**Your Ref: 2026/0085
Our Ref: B/00188**

17th February 2026

38 Hoyle Mill Road, Stairfoot, Barnsley - (BARN) Retention of outbuilding with new foundation details involving removal of existing concrete base and placement on proposed wooden decking. (Amended Application)

Drawing Title
Existing plans A3

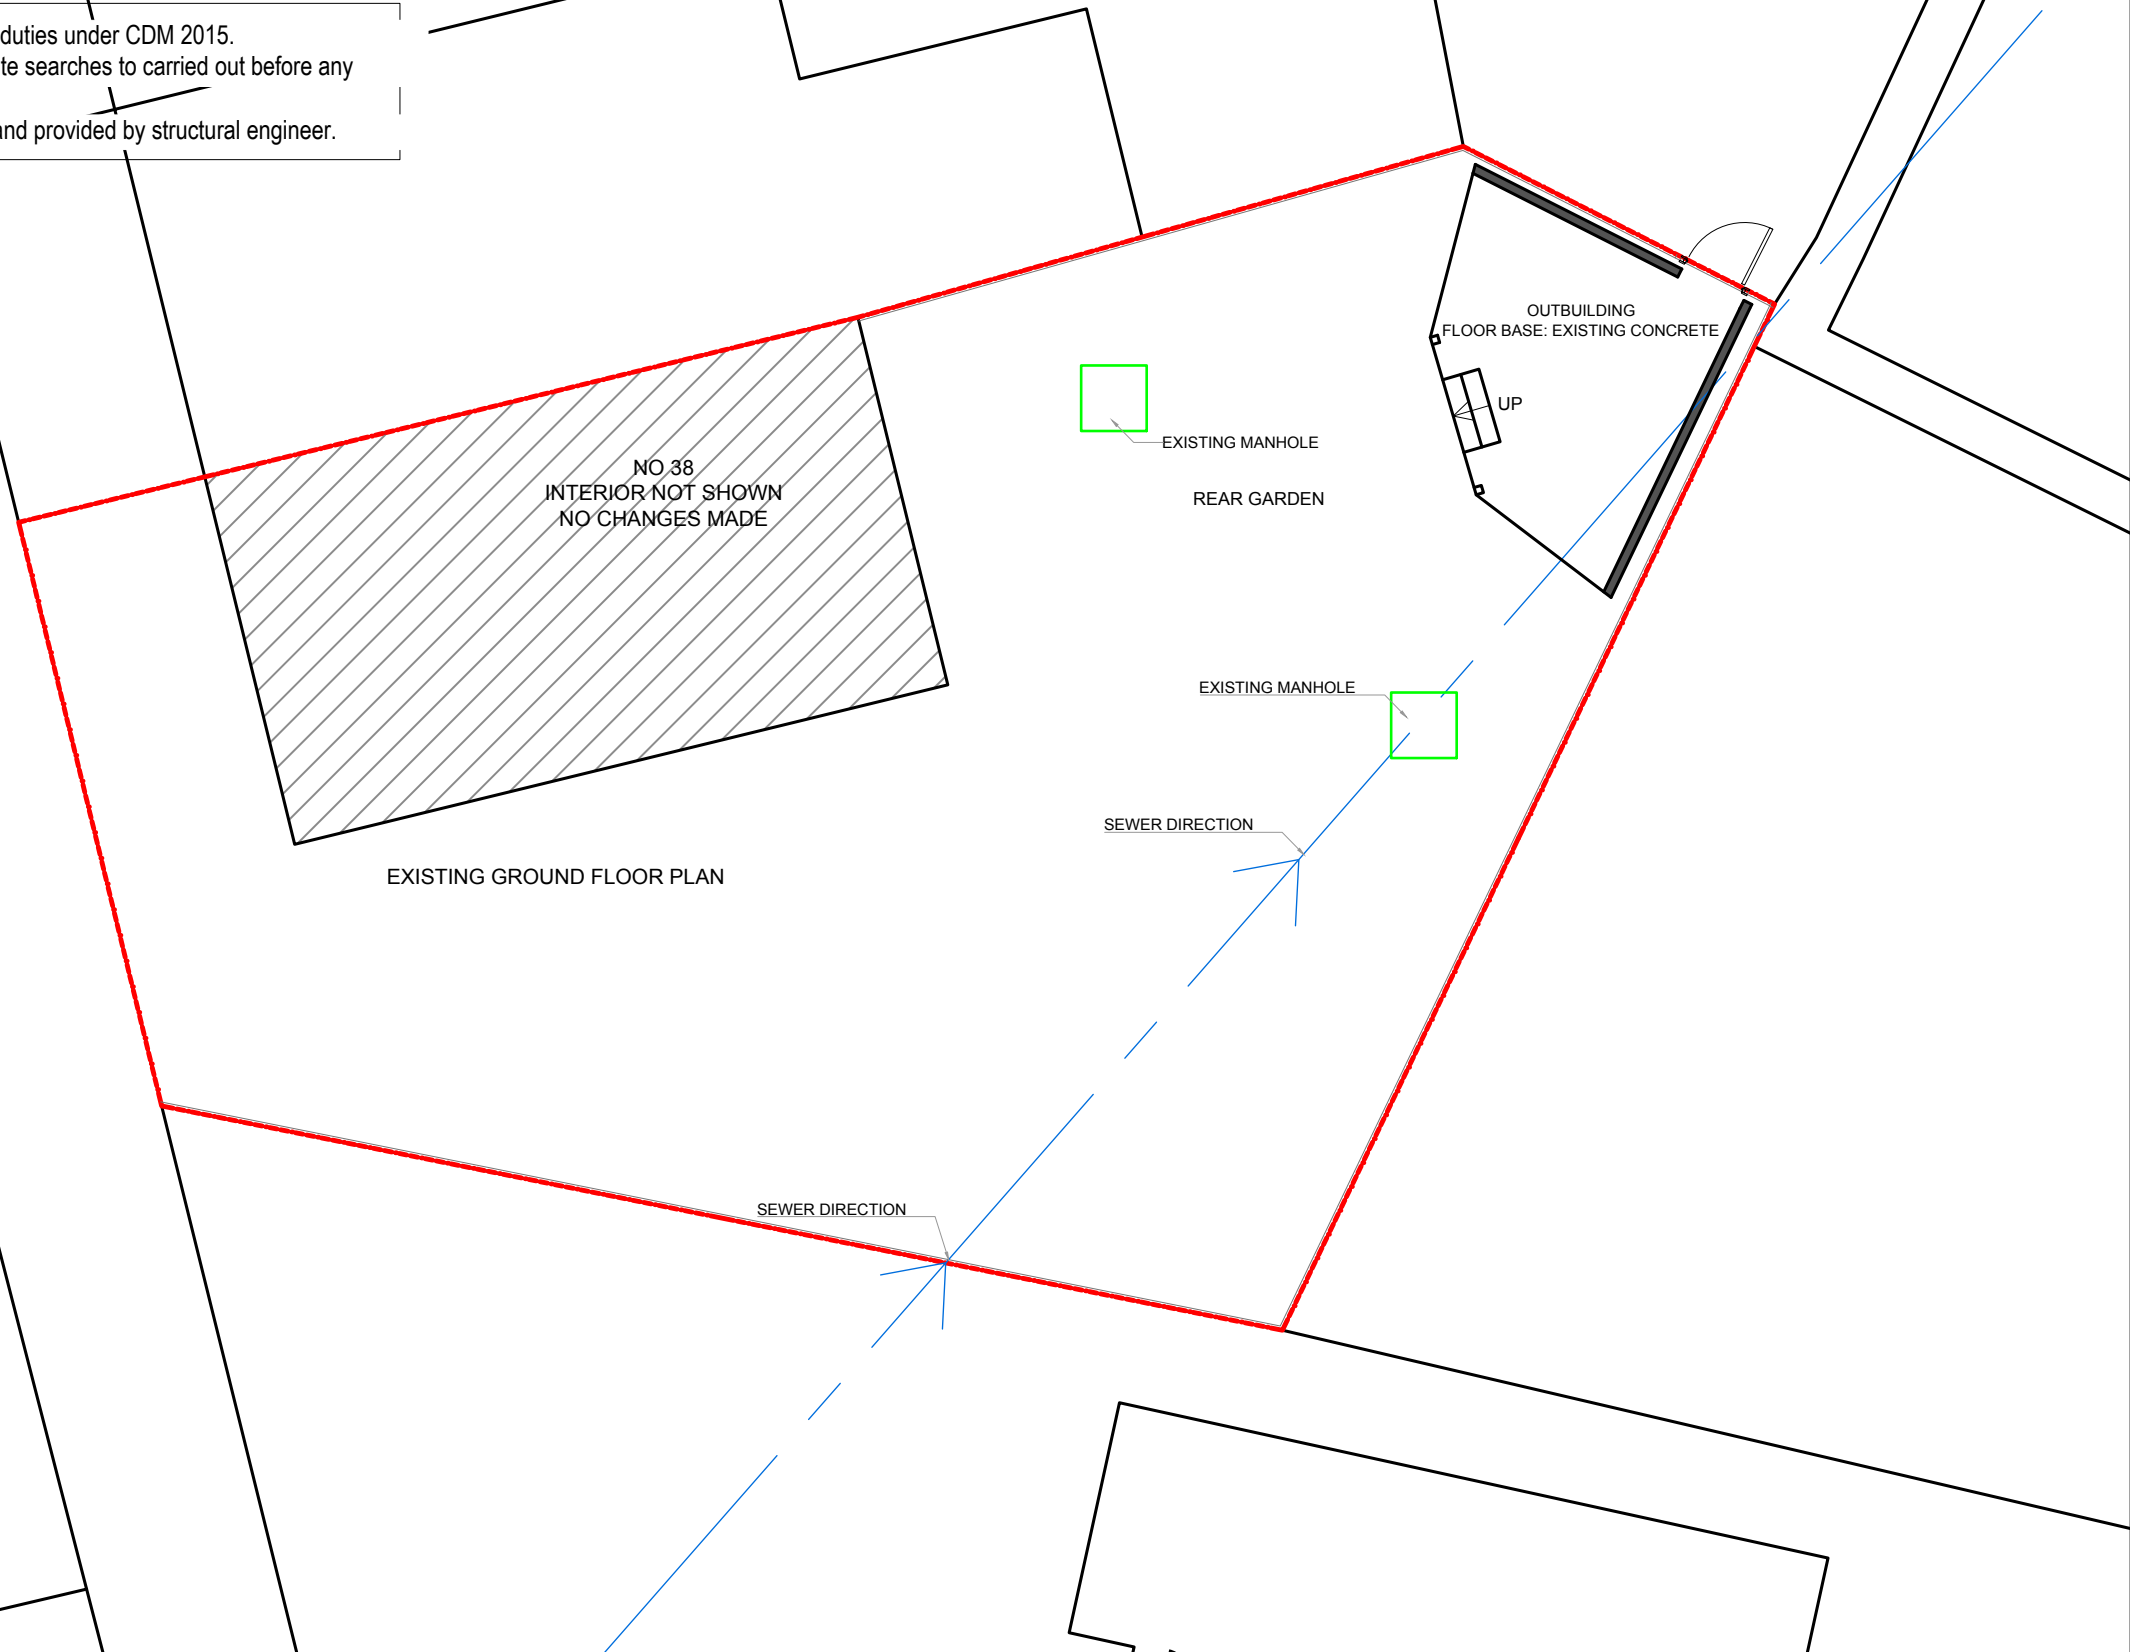
1.) The drainage details submitted on drawing 'Existing plans A3' P4 dated 05/01/26 that has been prepared by Studio Charrette is not acceptable. The following point(s) should be addressed:

- a.) the submitted drawing appears to show a building proposed to be built-over the line of public sewer crossing the site -- contrary to our request
- b.) the submitted drawing should show the site-surveyed position of the public sewer crossing the site
- c.) the submitted drawing should show the required building stand-off from public sewer -- or an agreed alternative scheme

2.) On the Statutory Sewer Map, there is a 525 mm diameter public surface water sewer recorded to cross the site. It is essential that the presence of this infrastructure is taken into account in the design of the scheme.

- a.) It may not be acceptable to raise or lower ground levels over the sewer and we will not accept any inspection chambers on the sewer to be built over.
- b.) In this instance, a stand-off distance of 3.5 (three point five) metres is required at each side of the sewer centre-line and it may not be acceptable to raise or lower ground levels over the sewer, nor to restrict access to the manholes on the sewer.
- c.) A proposal by the developer to alter/divert a public sewer will be subject to Yorkshire Water's requirements and formal procedure in accordance with Section 185 Water Industry Act 1991.
